# WATERVIEW NORTH

## RESIDENTIAL ZONING - RM-30

LOCATED IN A PORTION OF SECTIONS 8 & 9,  
T15S, R65W OF THE 6TH P.M.,  
EL PASO COUNTY, COLORADO

## RESIDENTIAL ZONING - RM-30

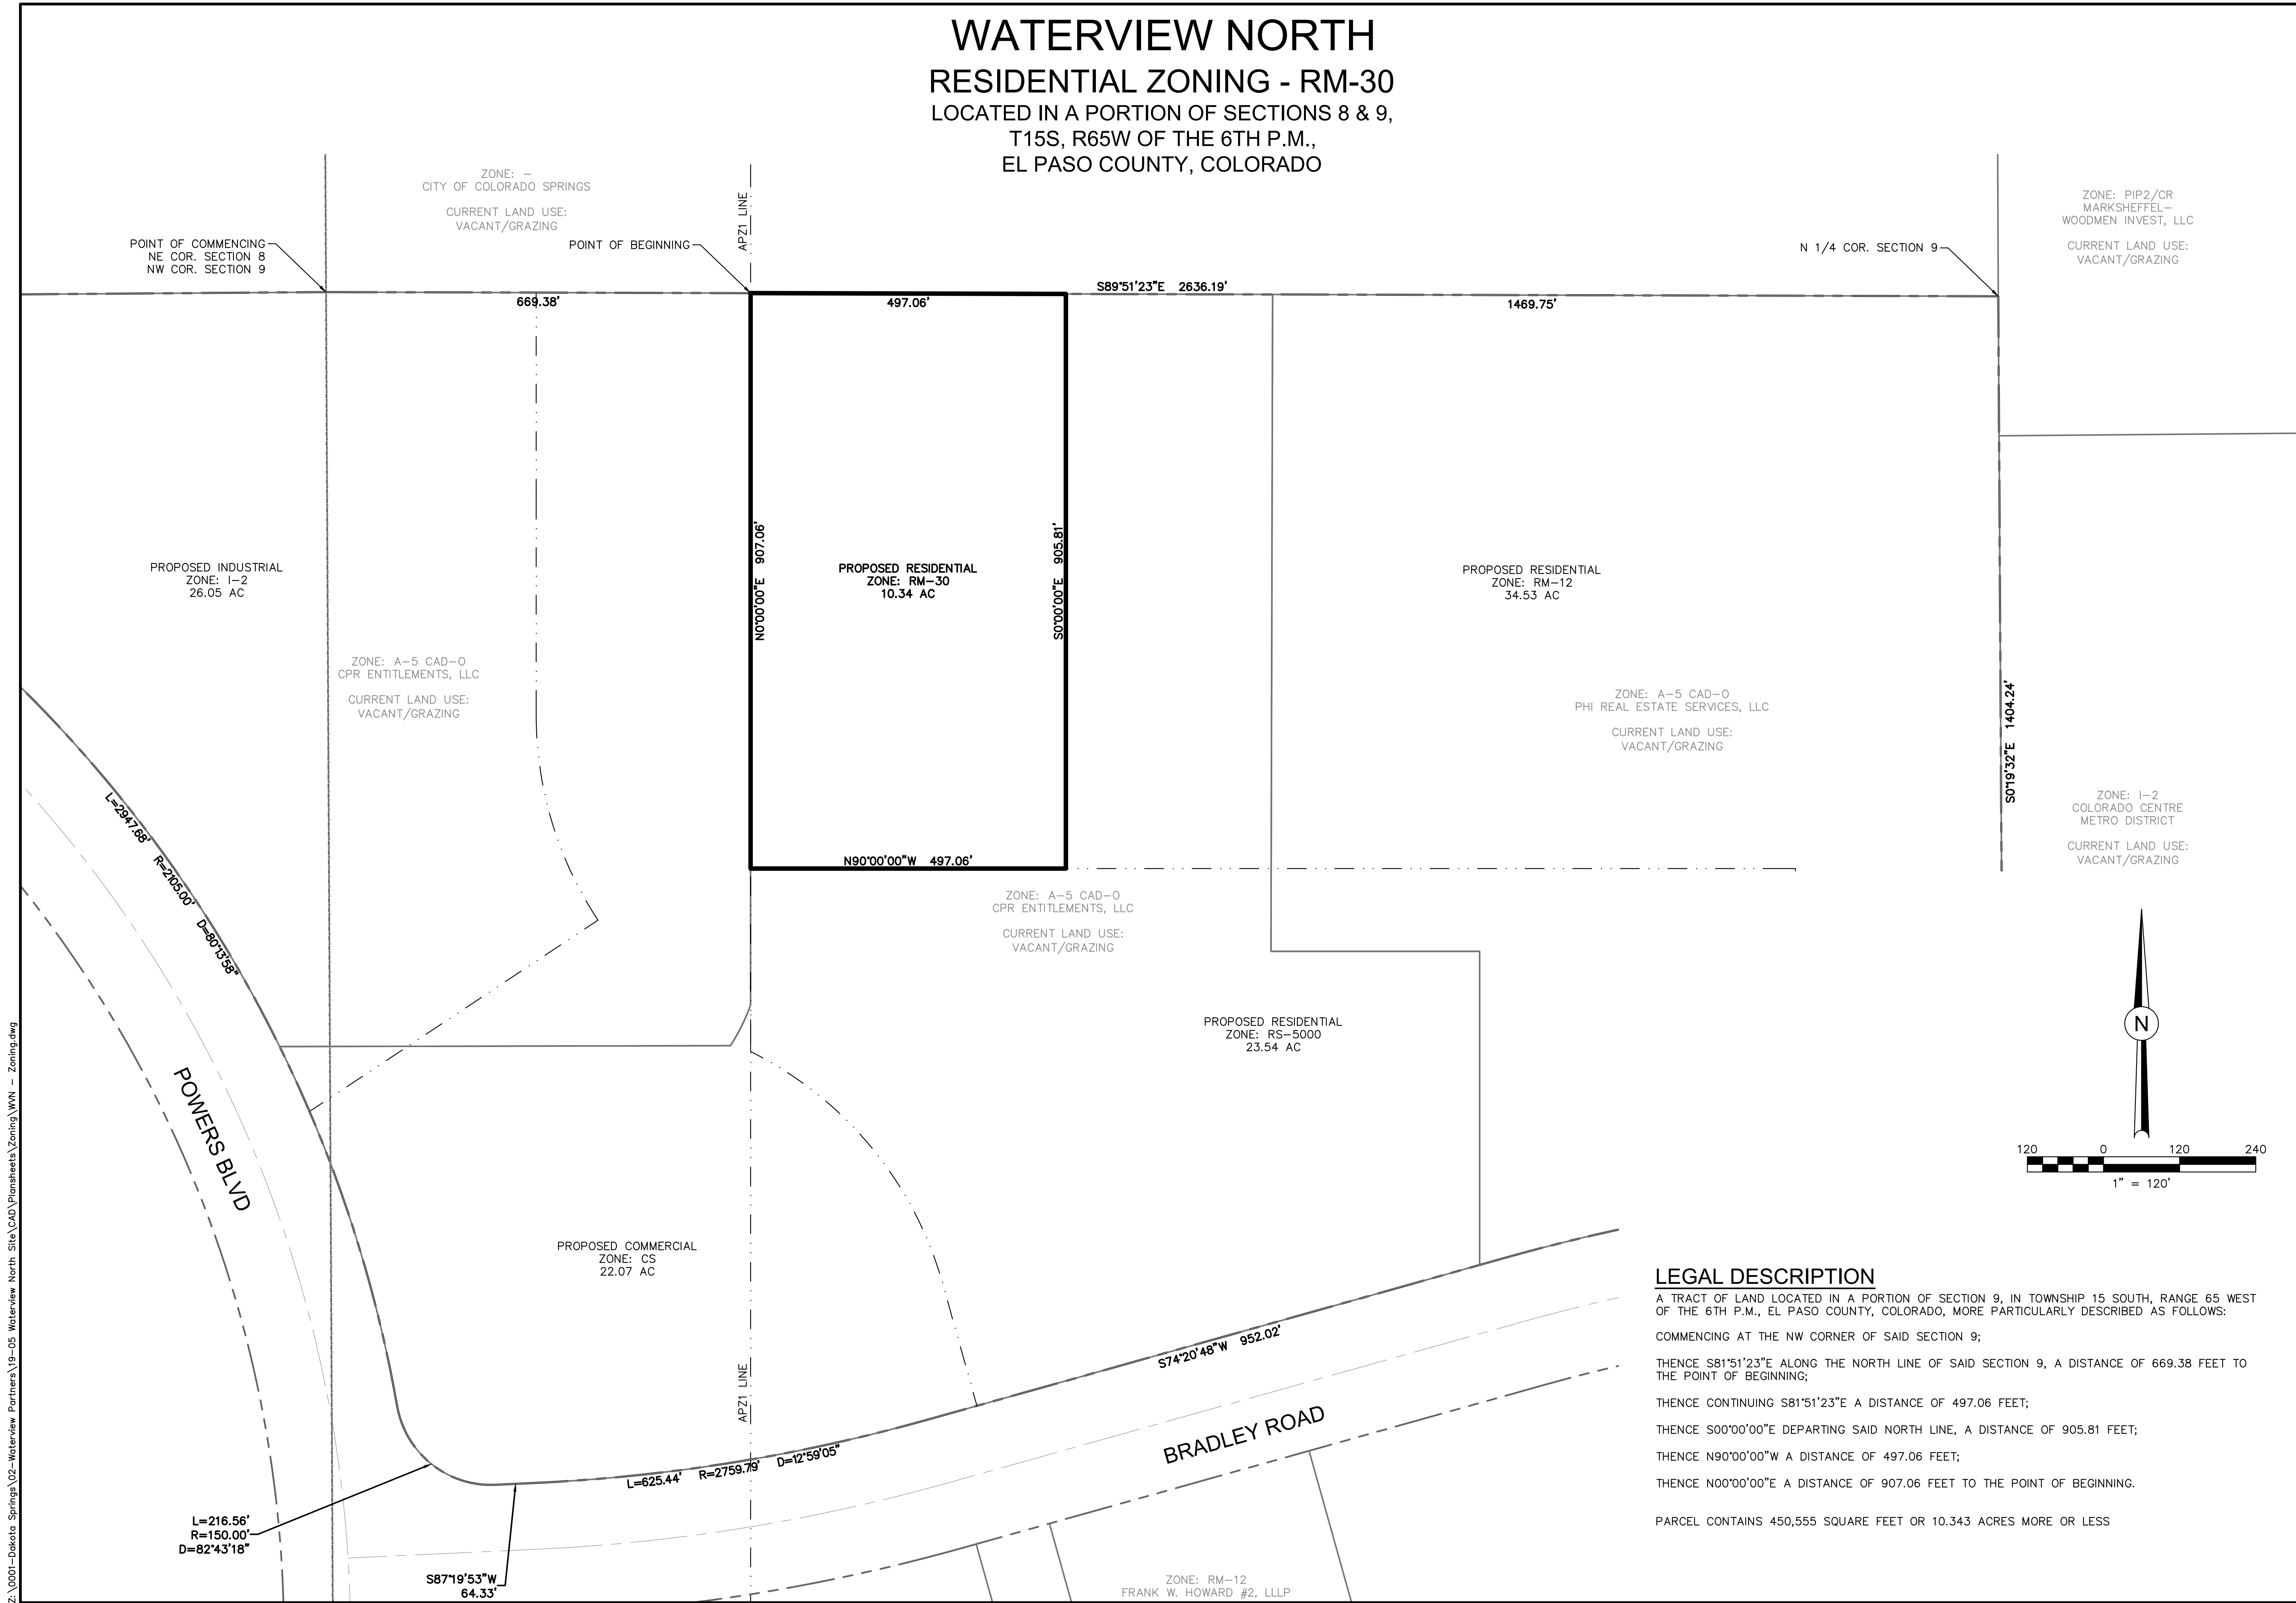
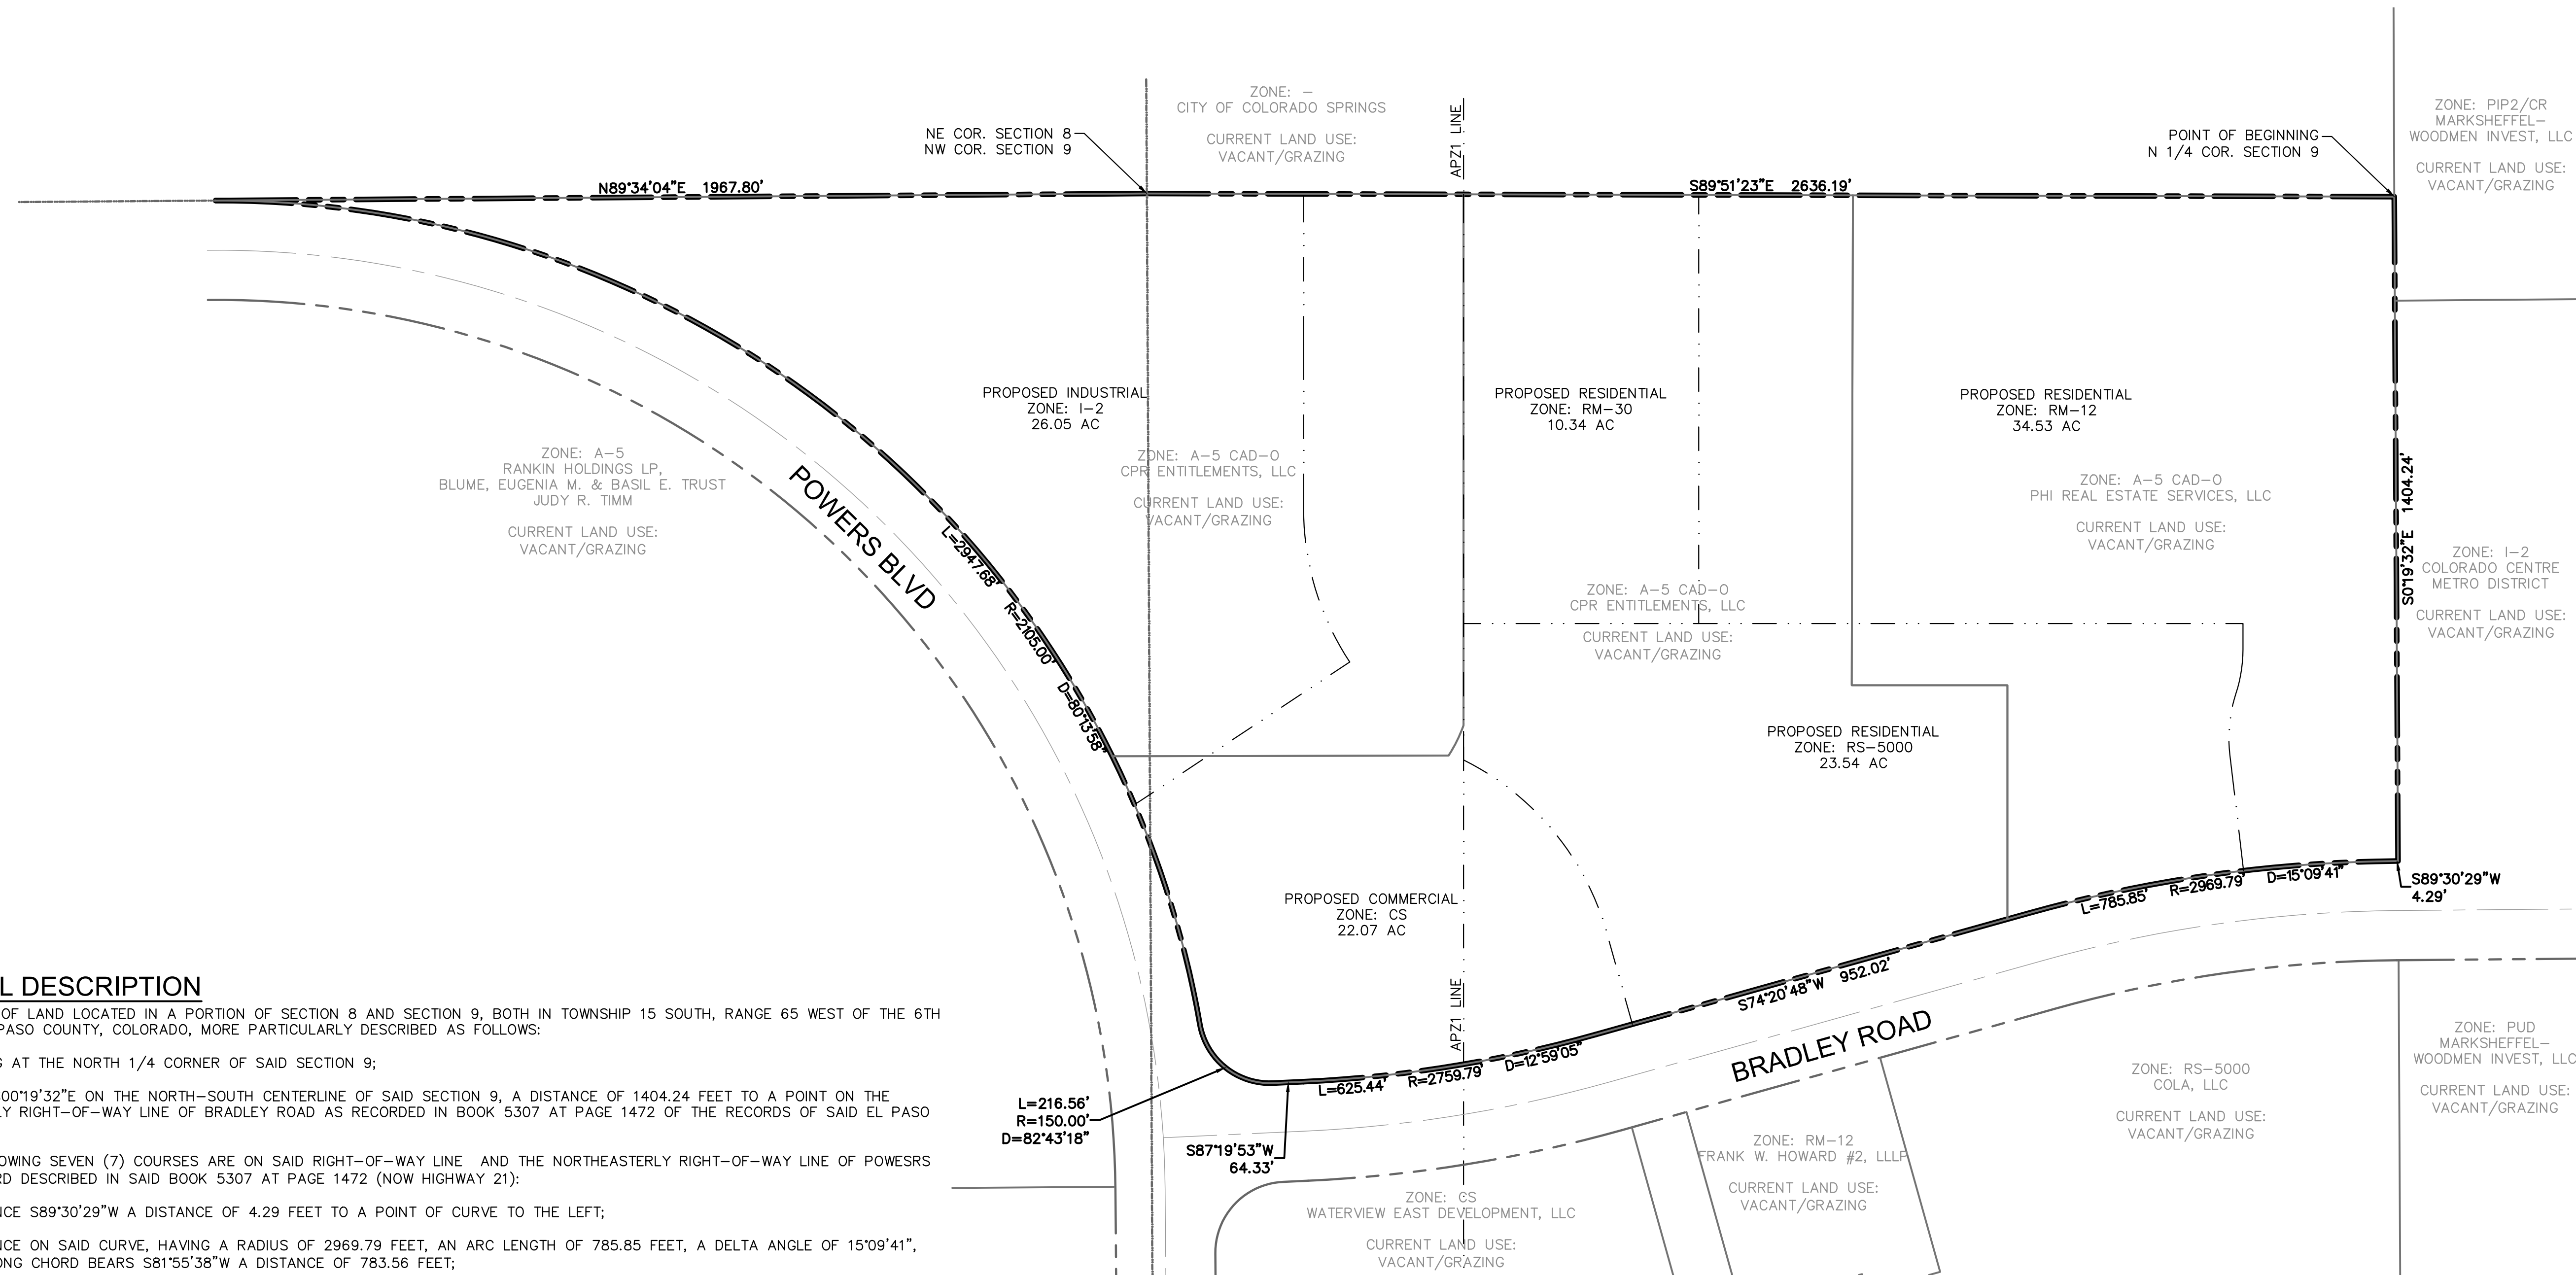
-we prefer that you remove the second page as those properties are not part of this request  
-please show adjacent lot ownership and lot numbers (comment applies to both pages)  
-please add existing easements to document  
-please add the name, address, phone number, and email address for property owner and applicant
